Please ask for: Mrs D Johnson
Email: daun.johnson@arun.gov.uk
Telephone: 01903 737762
Our Ref: FP/52/21/PL
Your Ref:
Date: 10th March 2021

Application for Planning Permission

Development: Partial retention, extension & reconstruction of 2-Storey building to provide 1 No. Class E shop unit, 1 No. Flexible use commercial unit for any Use within Class E or as a Sui -Generis beauty therapist/nail bar & 3 No. 2 bed flats to include parking, secure cycle & refuse storage facilities (resubmission following FP/258/19/PL). This site is in CIL Zone 4 (Zero Rated) as flats & other development.

Location: 107 Felpham Way Felpham PO22 8QB

PROPOSED FIRST FLOOR PLAN

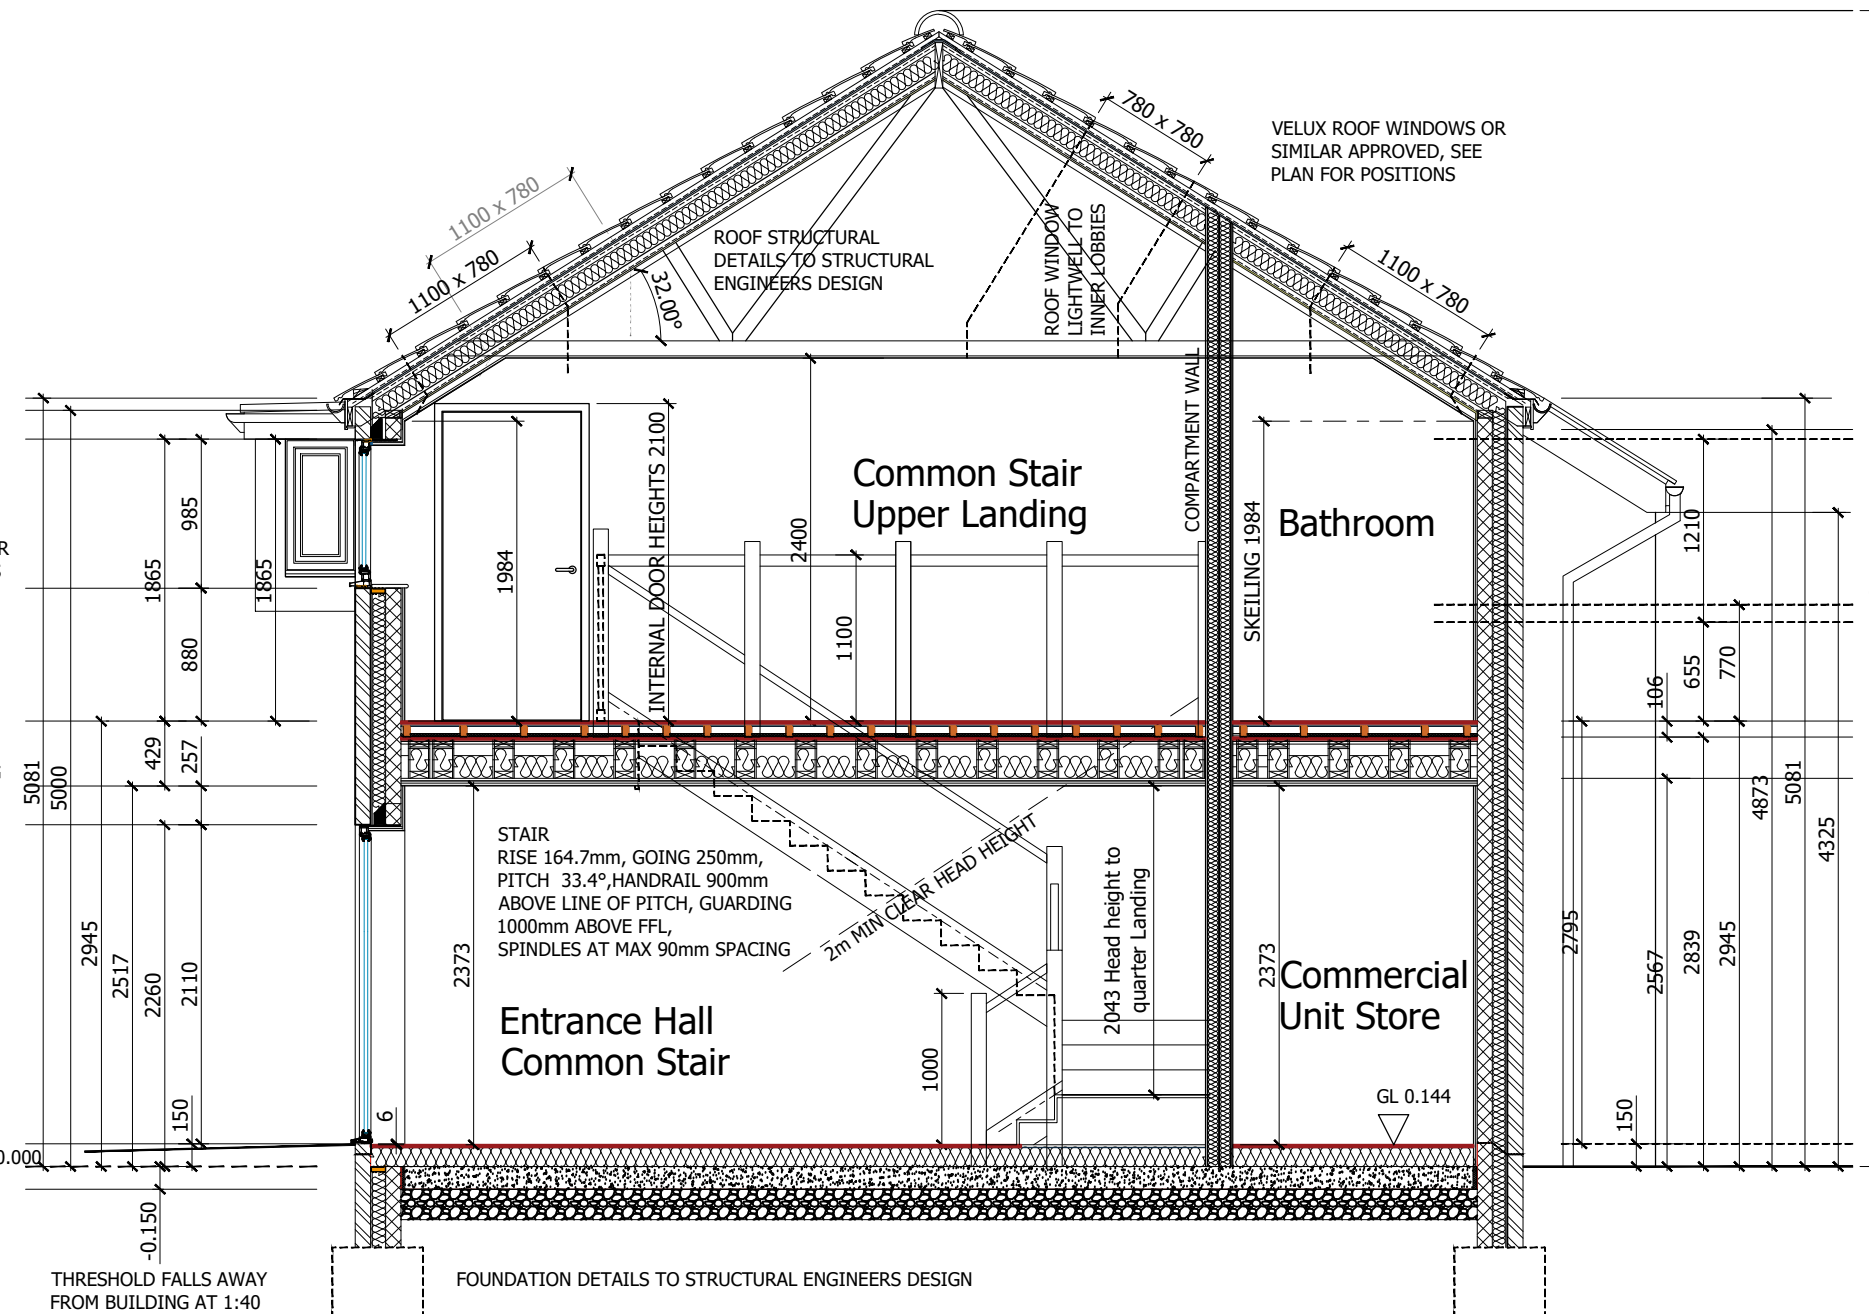
The proposed first floor plan and east elevation do not accord. Please amend accordingly.
